PROJECT NO.	1001992	APPLICATION NO.	02DRB 01187
PROJECT NAME	Lands of Dan Lopez		
EPC APPLICATION NO.			
APPLICANT / AGENT	Wayjohn Surveying	PHONE NO.	255-2050
ZONE ATLAS PAGE	5-14		
ONE STOP COMMENT FORM LOG

⁶
15. **Project #1001992**
Application # 02DRB-00847
Lands of Dan Lopez

Project Number: 1001992
Application Number: 02DRB-00847

SKETCH PLAT OF
 LOTS 1 AND 2
 LANDS OF DAN LOPEZ
 ALBUQUERQUE, BERNALILLO COUNTY, NEW MEXICO

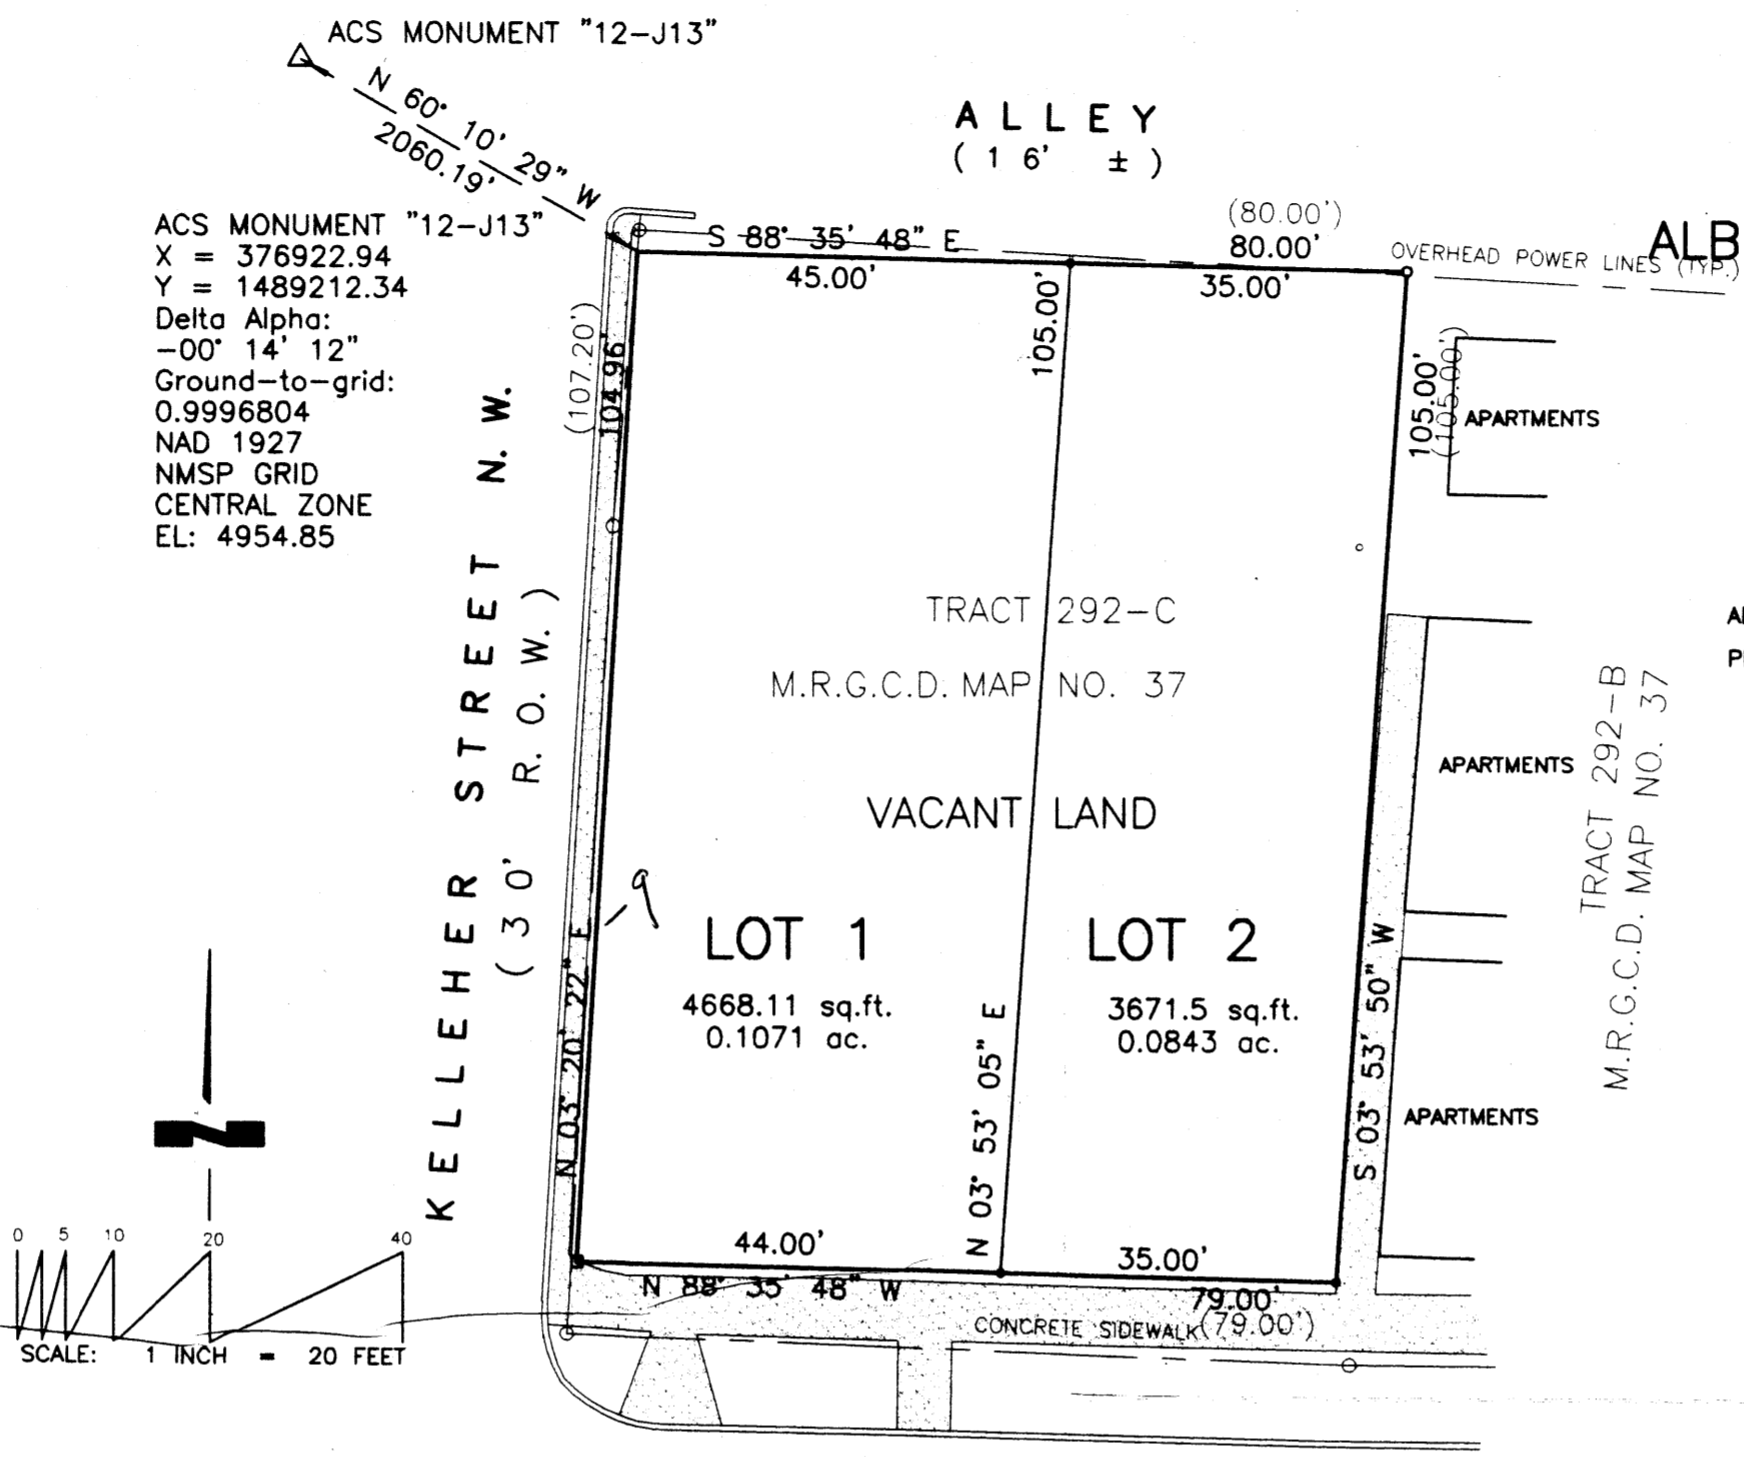
1. All R-2 zoning requirements (lot width, lot area, setbacks, open space, etc.) must be met unless granted a variance by the Zoning Hearing Examiner. If the requirements cannot be met, contact Tom Rojas at 924-3938 for further information regarding the variance process.

*Lot 2 needs sanitary sewer easement to Kelleher St;
No Sanitary sewer in front of property.*

No.	Comment
<input type="checkbox"/>	Dedication of right-of-way to provided 9 feet from the face of curb to the property line is needed.

PLAT OF
 LOTS 1 AND 2
 LANDS OF DAN LOPEZ
 ALBUQUERQUE, BERNALILLO COUNTY, NEW MEXICO

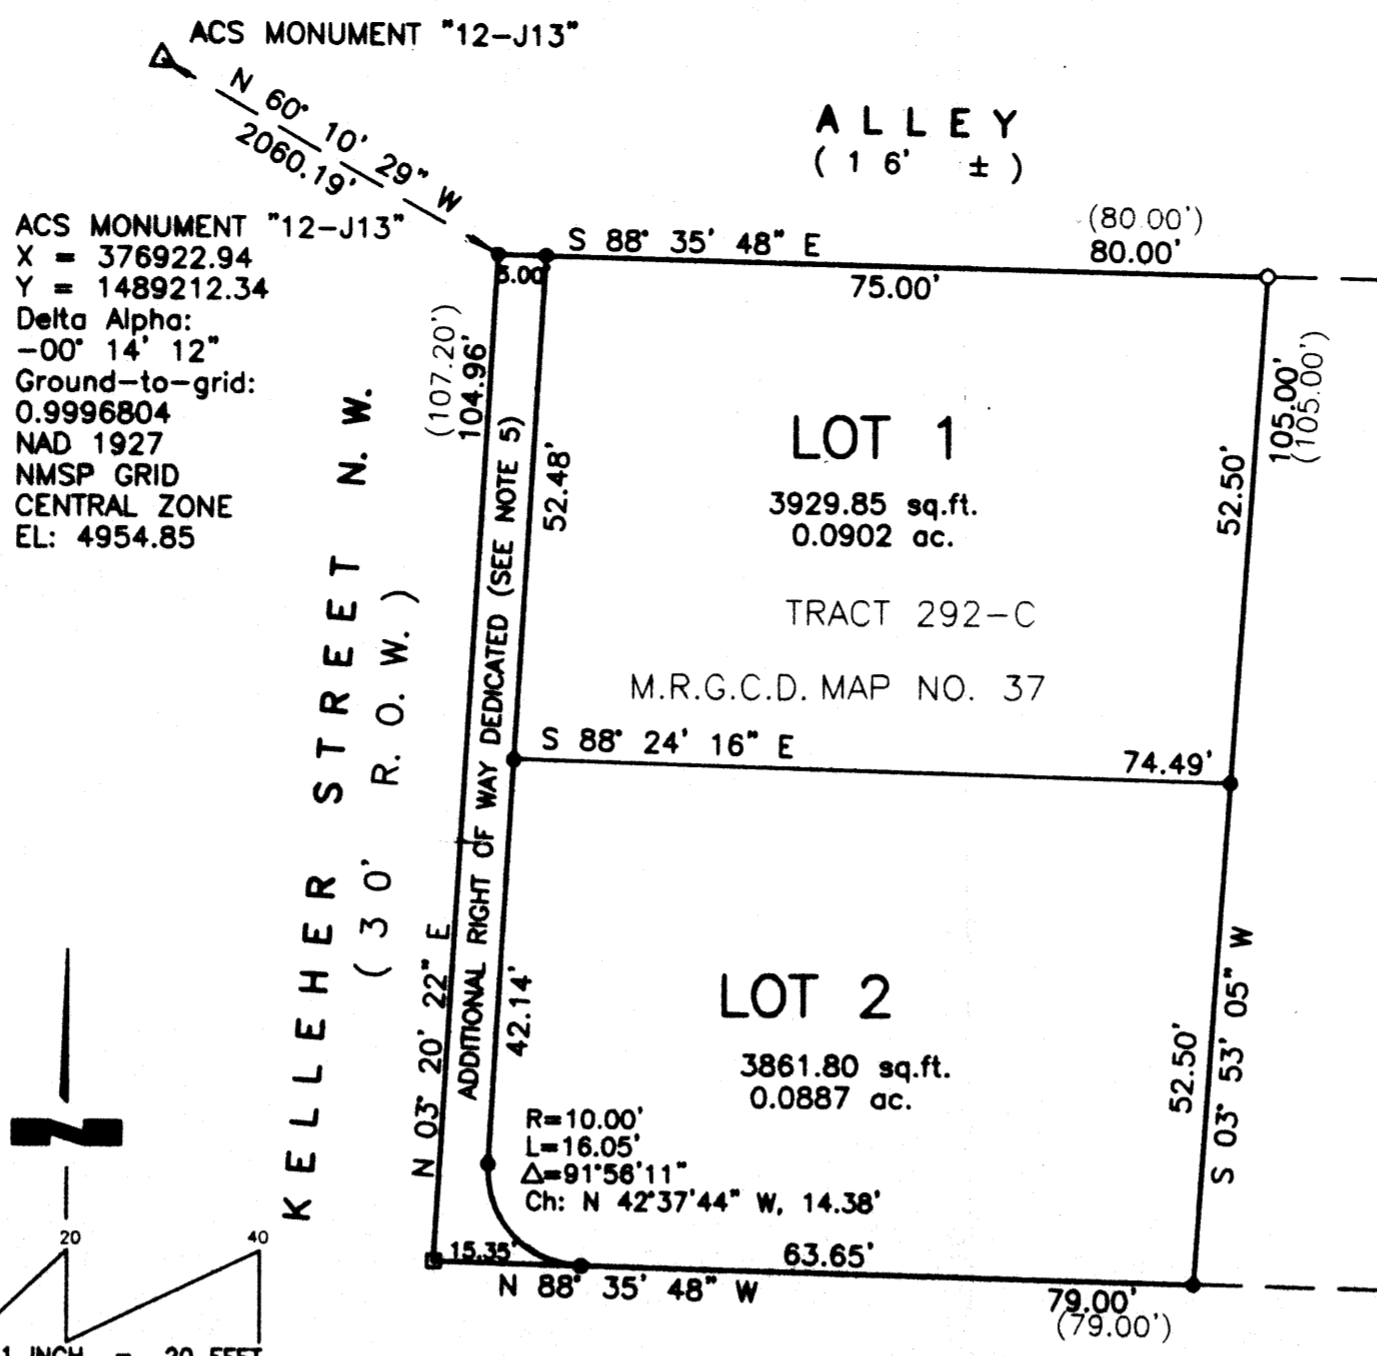
TRANSPORTATION DEV (505) 924-3990			
PLANS DISAPPROVED	NSF	DATE	7/30/02
PLANS APPROVED	RV	DATE	8-02-02
COMMENTS:			
- IF 5' of ROW has been dedicated to the City, has it been reflected on Kelleher St. ROW? ✓

① The site is actually zoned SU-2 MDA according to the AGIS database. Please revise the zoning on the plat. ② Future development must be in compliance with the Downtown Neighborhood Area sector development plan. ③ Property Management's signature is not required on this particular plat and may be marked "in/a". ④ Minor plats (if not completing a vacation) may be recorded by the applicant/agent. A copy of the recorded plat must be provided to Planning in order to close the case file. ⑤ Please provide a digital dxf file showing easement, parcel & right-of-way lines in New Mexico State Plane Feet, NAD 1927. (Return form with plat / site plan)
